# CITY OF ALBUQUERQUE

**Re: Townhouses for Buchanan**  
**4622 12<sup>th</sup> Street N.W.**  
**Traffic Circulation Layout**  
Engineer's/Architect's Stamp 09-13-16 (F14-D074)

Based upon the information provided in your submittal received 09-15-16, the above referenced plan cannot be approved for Building Permit until the following comments are addressed:

**CIVIL101**

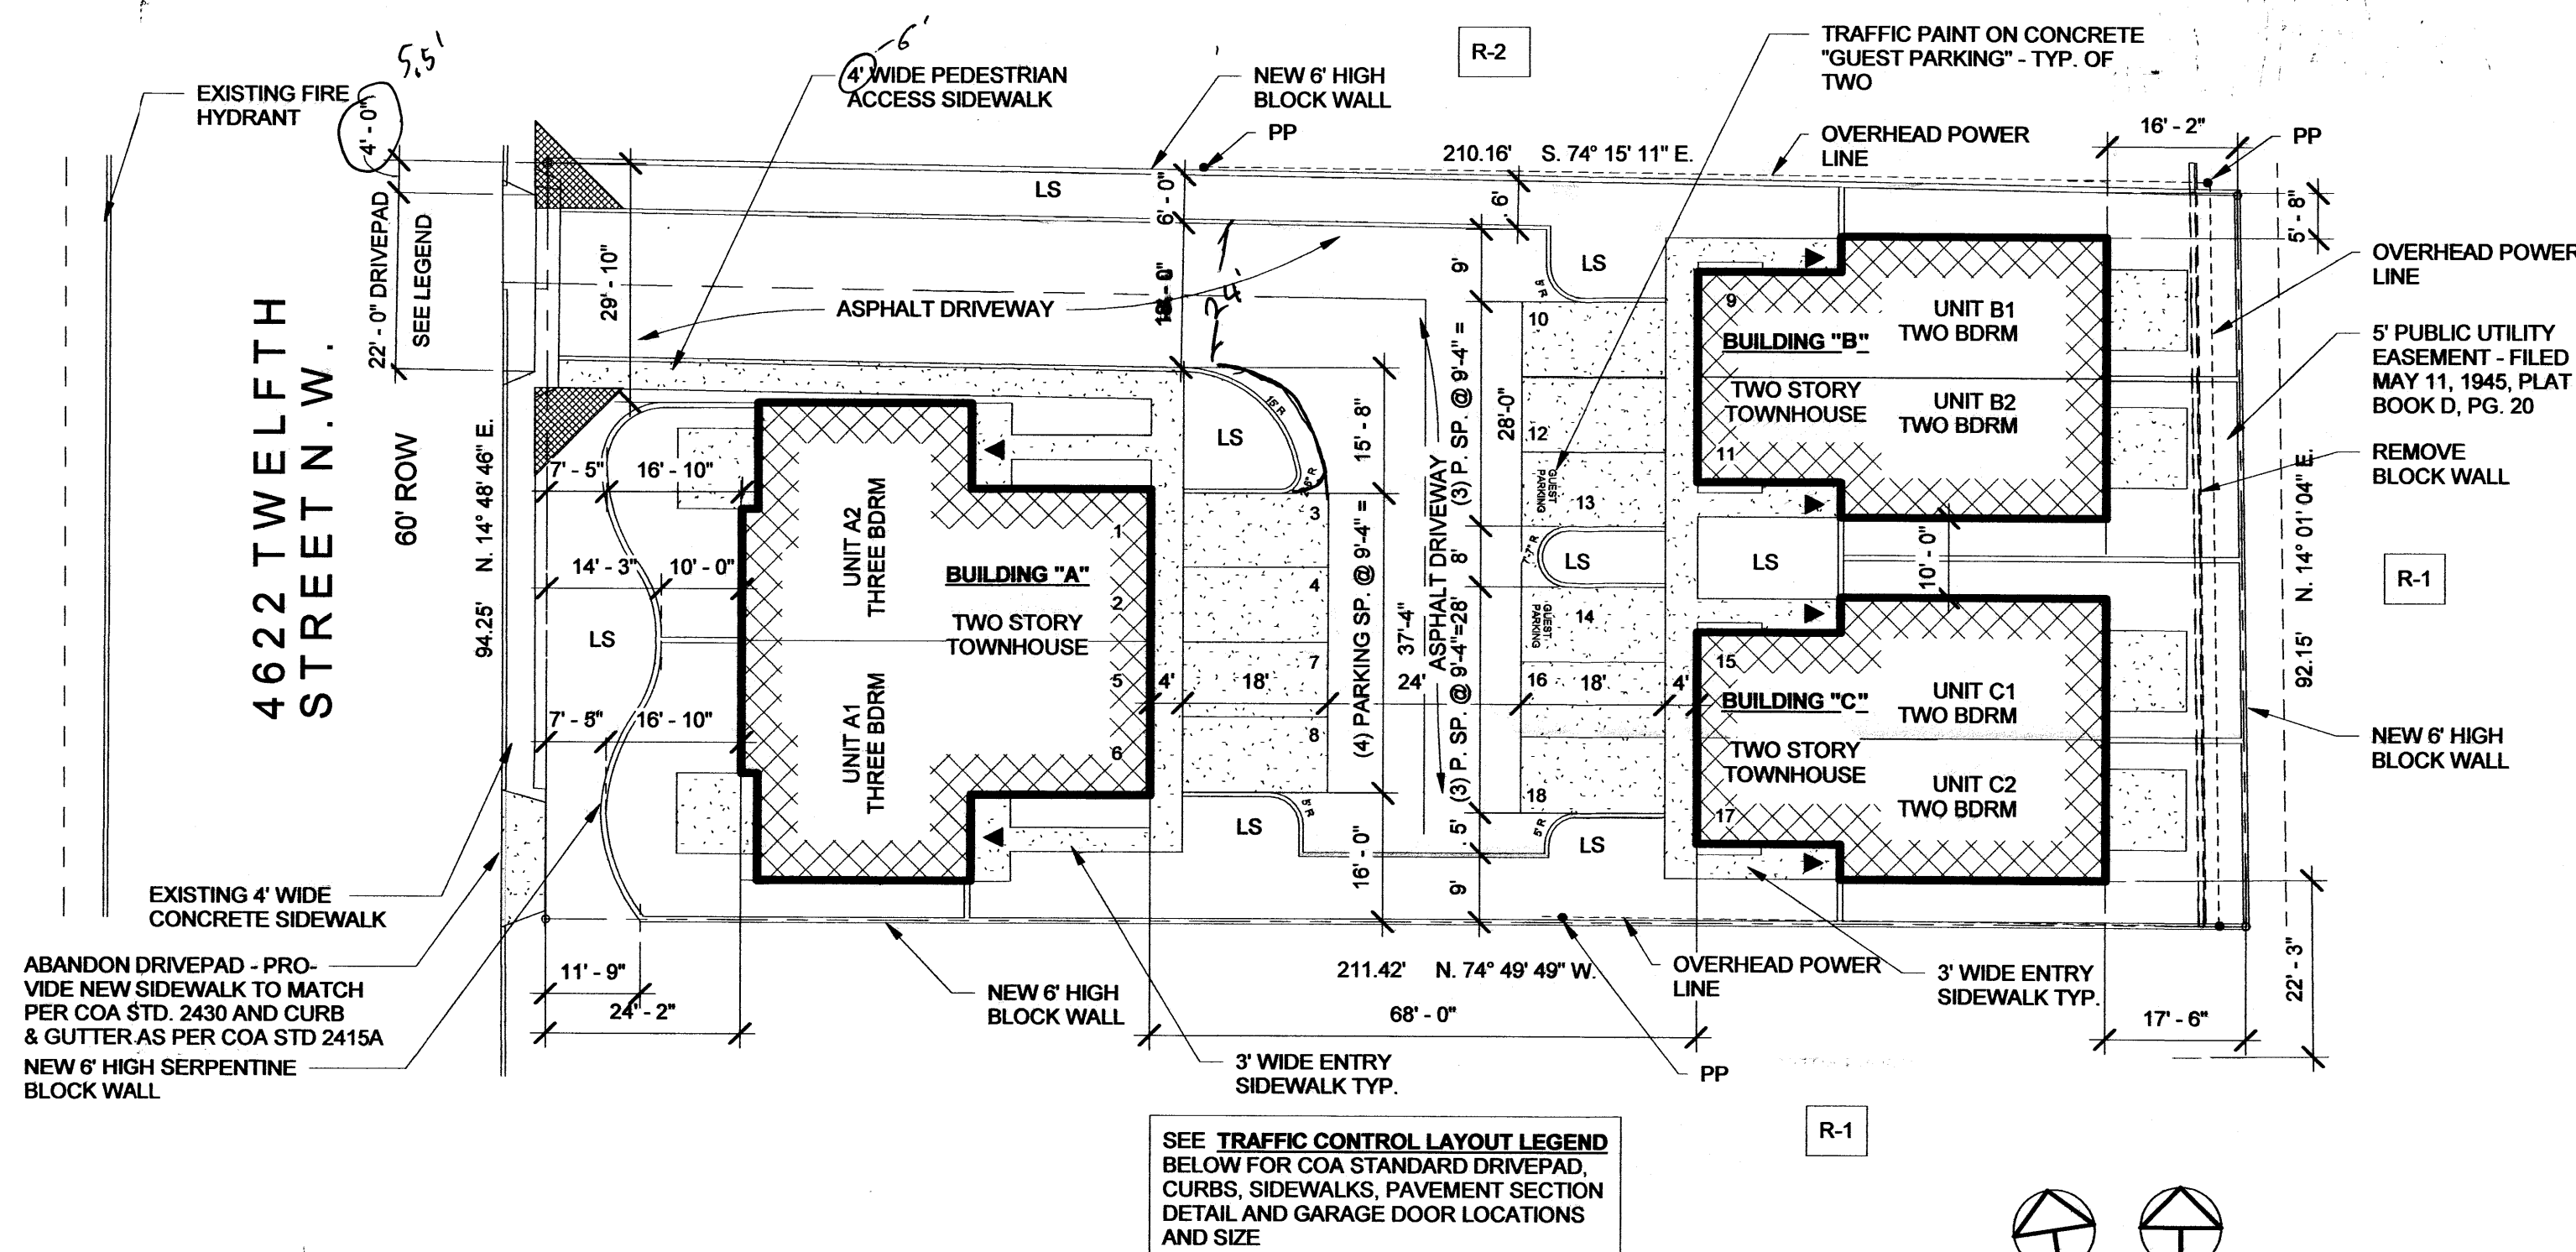
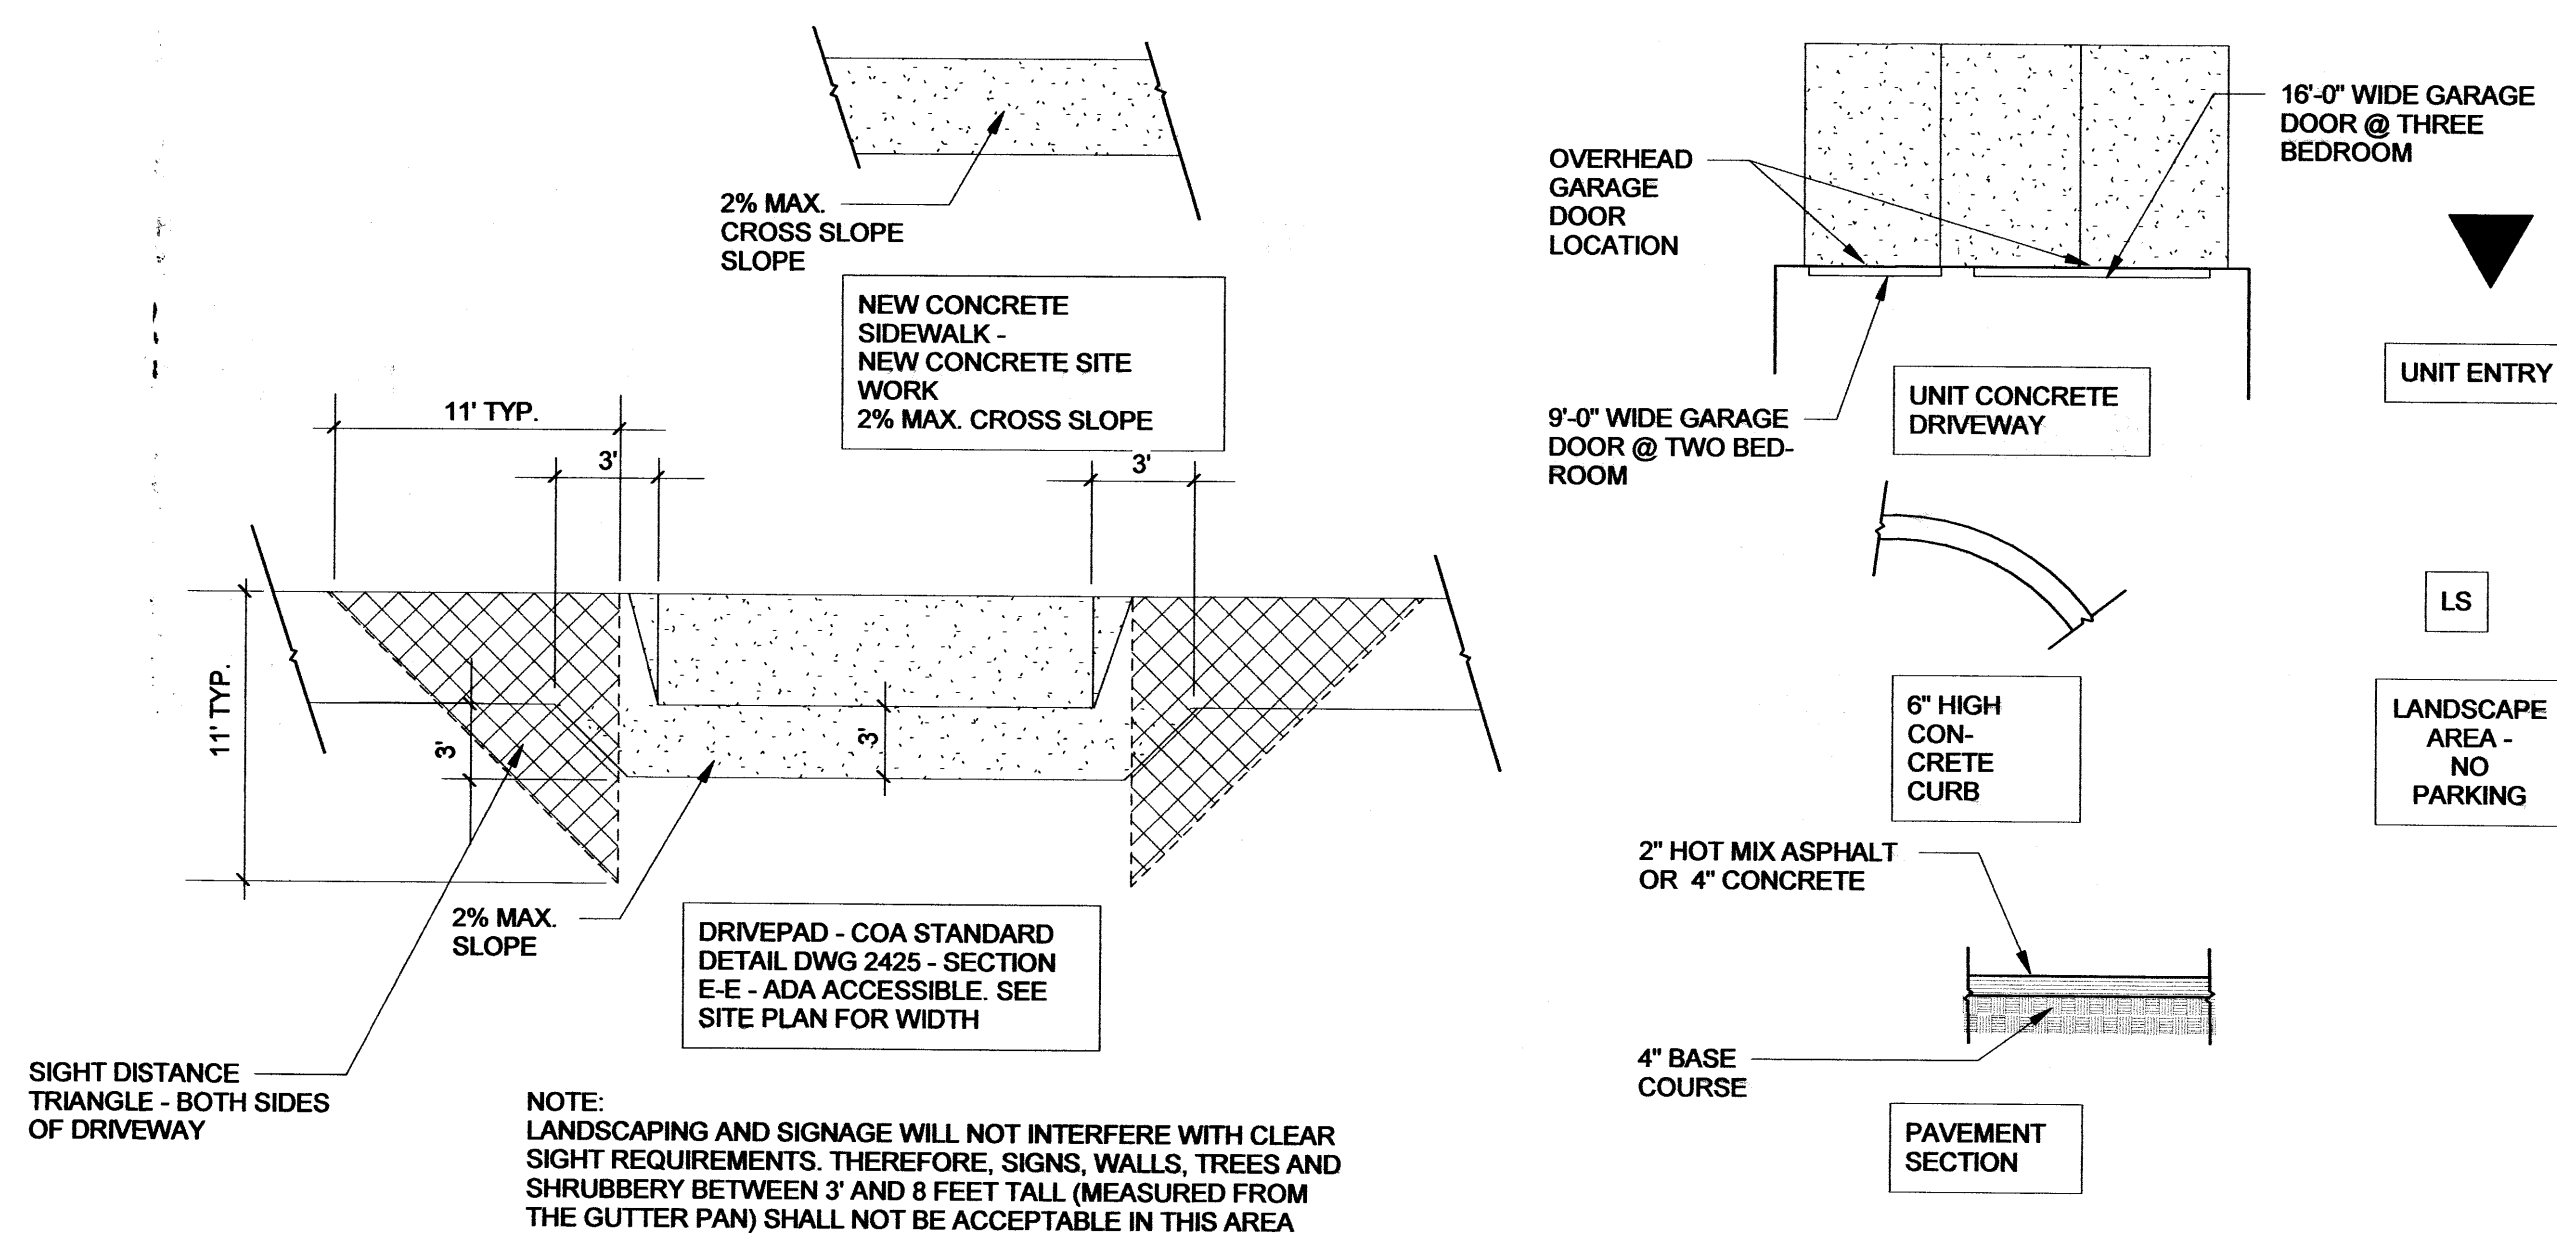
1. Identify the right of way width, and street widths on 12th Street.
2. Per the zoning code, a 6 ft. wide ADA accessible pedestrian pathway is required from the public sidewalk to the building entrances. Please clearly show this pathway and provide details. This path should extend to the two bedroom units as well.
3. Service vehicle and/or refuse vehicle maneuvering must be contained on-site; provide a copy of refuse approval.
4. If the drive pad is to be located closer than 5.5' from the property line, a letter of concurrence signed by the neighbor affected is required. Also, the width and location of the neighbors drive is needed.
5. The radius on the bum-out should extend to the end of the parking stall.
6. See Chapter 23, Section 6 of the City of Albuquerque *Development Process Manual*, for appropriate drive pad widths.
